Application No: AB/27/20/PL
Site Address: 6 The Old Slipway River Road Arundel BN18 9EY
Description of works: New balcony. This application may affect the setting of the Arundel Conservation Area.

Thank you for your internet representation made on 11th May 2020 which has been recorded as no objection with the comments as follows:

DRAWING
Second Floor Plan + Elevations
as Proposed

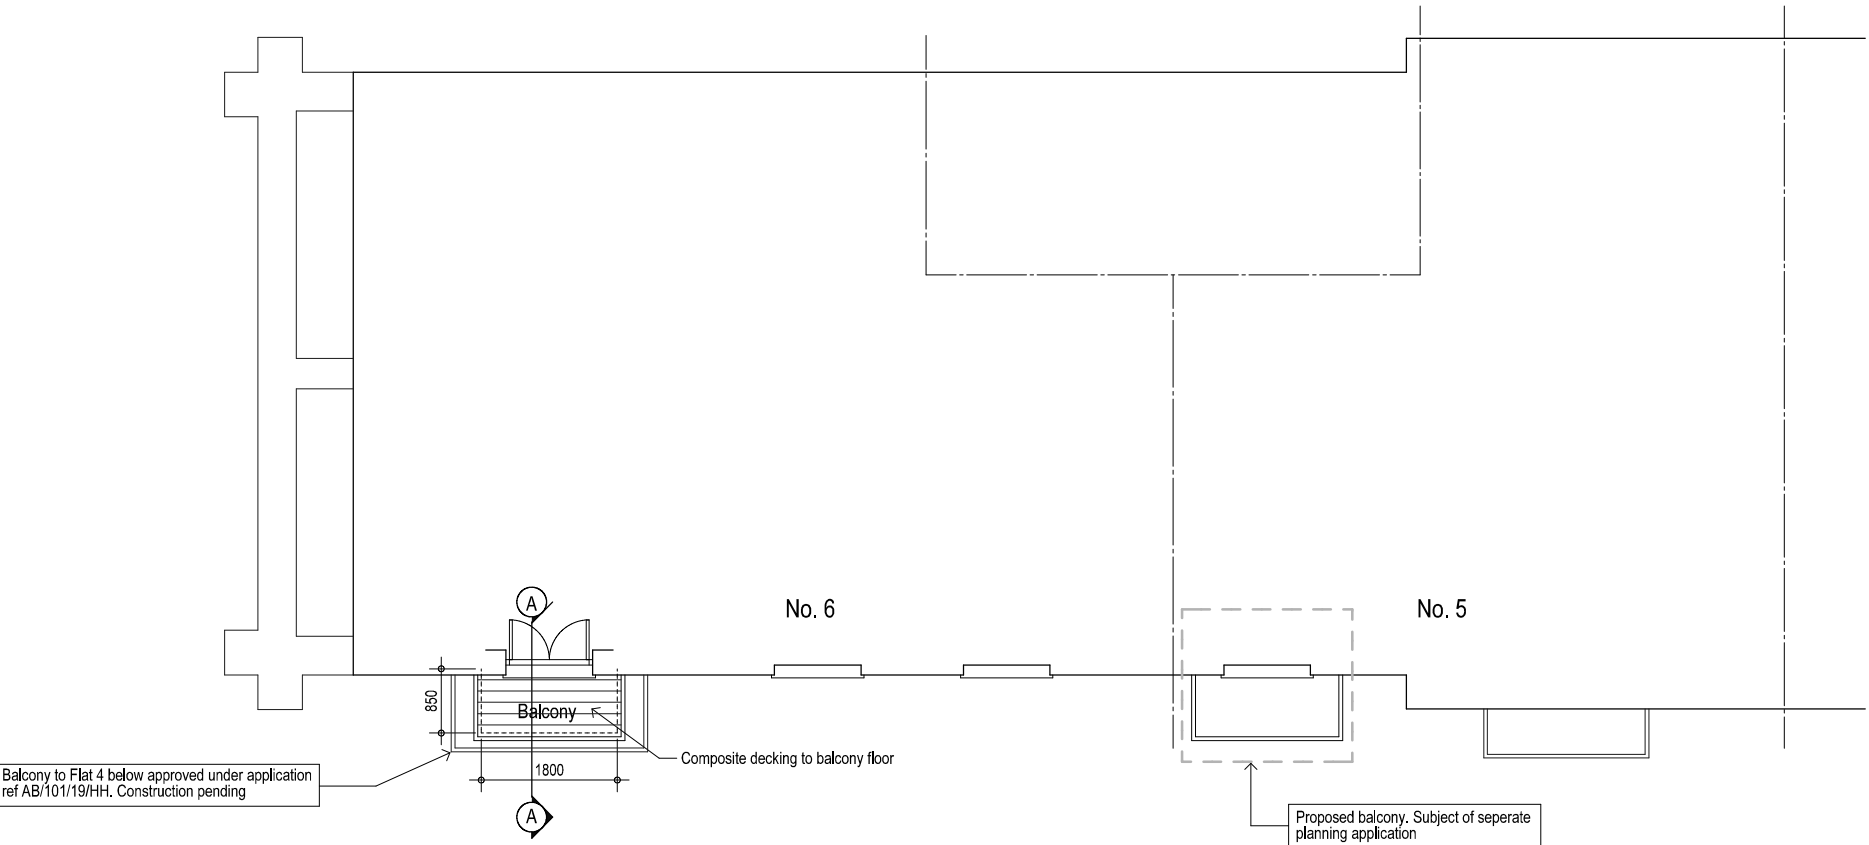
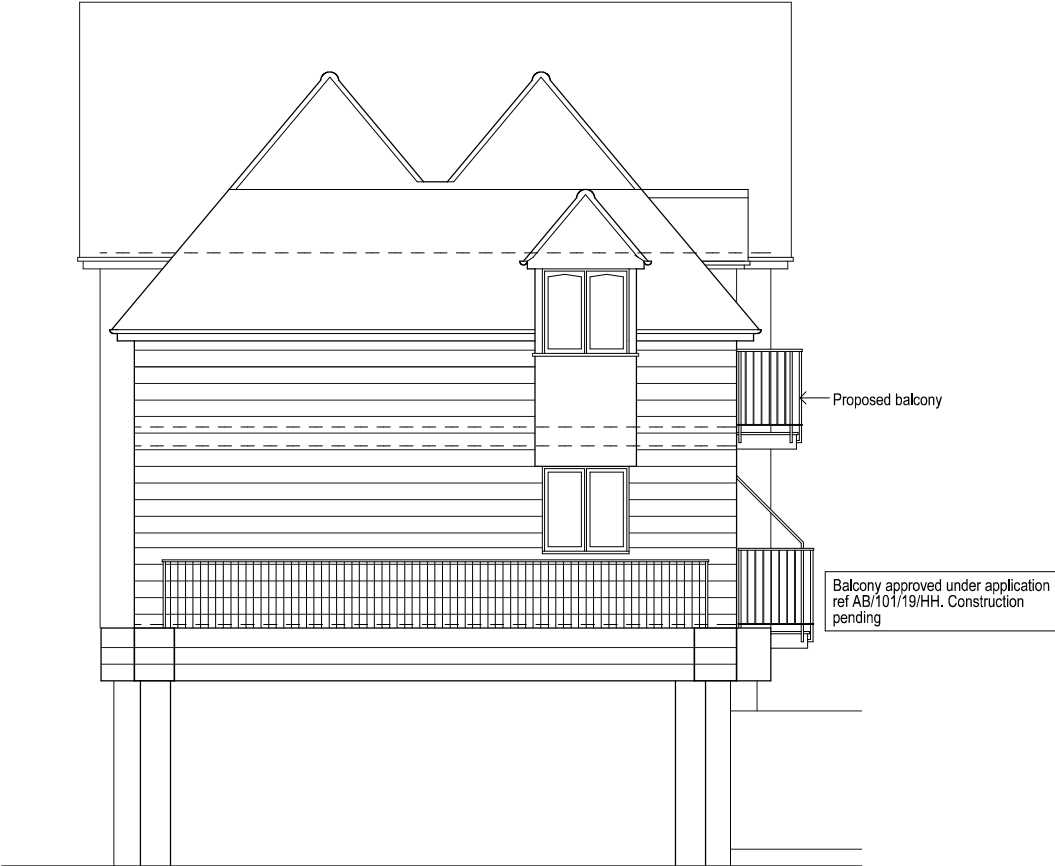
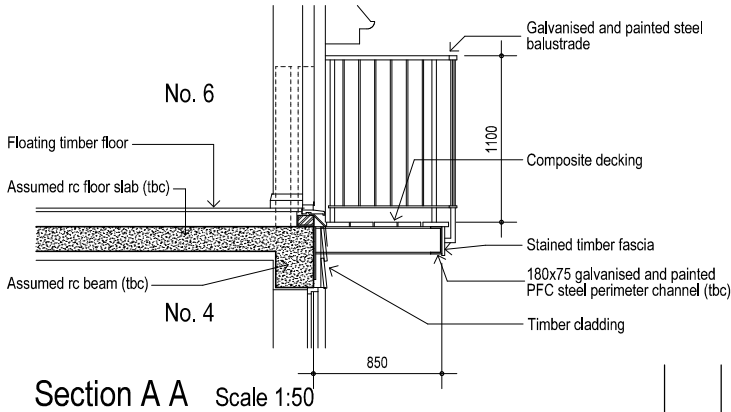
The scale, materials, proportion and size of the proposed balcony is sympathetic with those of the host building. It would be preferable if the proposal were implemented at the same time as the proposed second floor balcony for 5, The Old Slipway, as shown on the plans, because it would maintain the symmetry of the facade. However, given the small scale of the proposed balcony for no6, this is not considered essential.

It is suggested that a condition be attached to any planning permission requiring details of the colour of the paintwork for the balcony since it will be important to ensure a consistent colour scheme for all new balconies on the river elevation of the building. The new French doors also need to match existing ones in external appearance, including colour.
